# Charlotte Department of Transportation

## Memorandum

**Date:** June 25, 2008

**Subject:** Rezoning Petition 08-060: Located on the east side of Point O'Woods Drive and the west side of Northlake Centre Parkway (Revised 6/20/08)

RZ-2.0

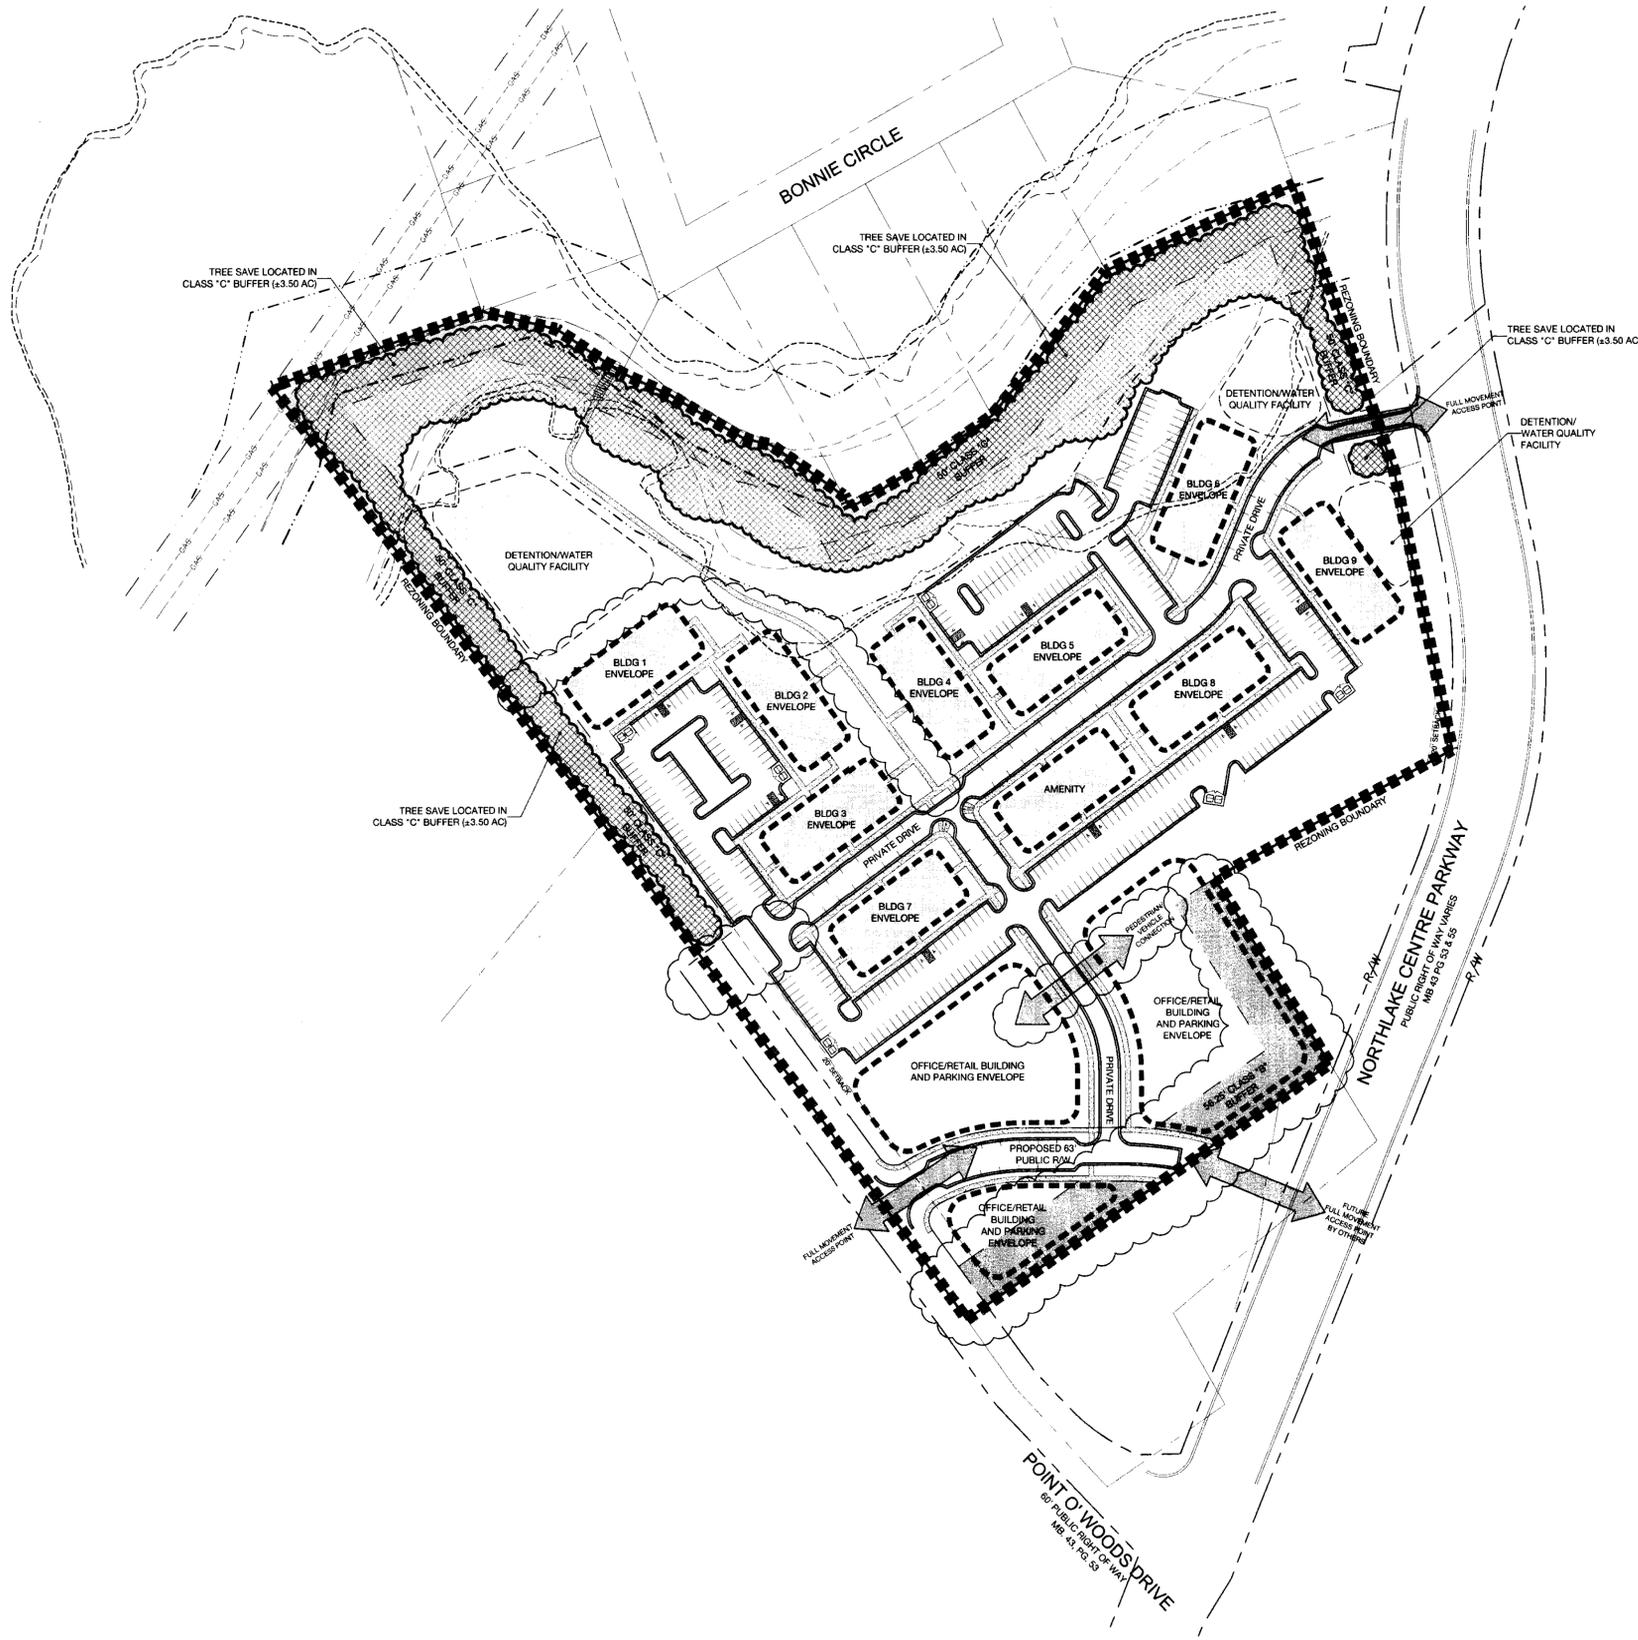
- Construct a third eastbound through lane on WT Harris Boulevard between Dixon Branch Creek and Northlake Centre Parkway and relocate/reconstruct the existing eastbound right-turn lane onto Reames Road.

- Extend the storage on the existing dual left-turn lanes on eastbound WT Harris Boulevard at Statesville Road to 400 feet for each lane (800 lane-feet) exclusive of bay taper.

2. The southern left-turn lane referenced in conditional note 7(H) must be constructed prior to issuance of any certificate of occupancy for any office or retail development on the site, regardless of the presence of the northern left-turn lane referenced in conditional note 7(F)

4. A minimum of 150 feet of internal channelization is necessary on the driveways/public streets connecting to Northlake Centre Parkway.
  5. A minimum of 150 feet of storage needs to be provided on all single left-turn lanes, including those on driveways to traffic signals.
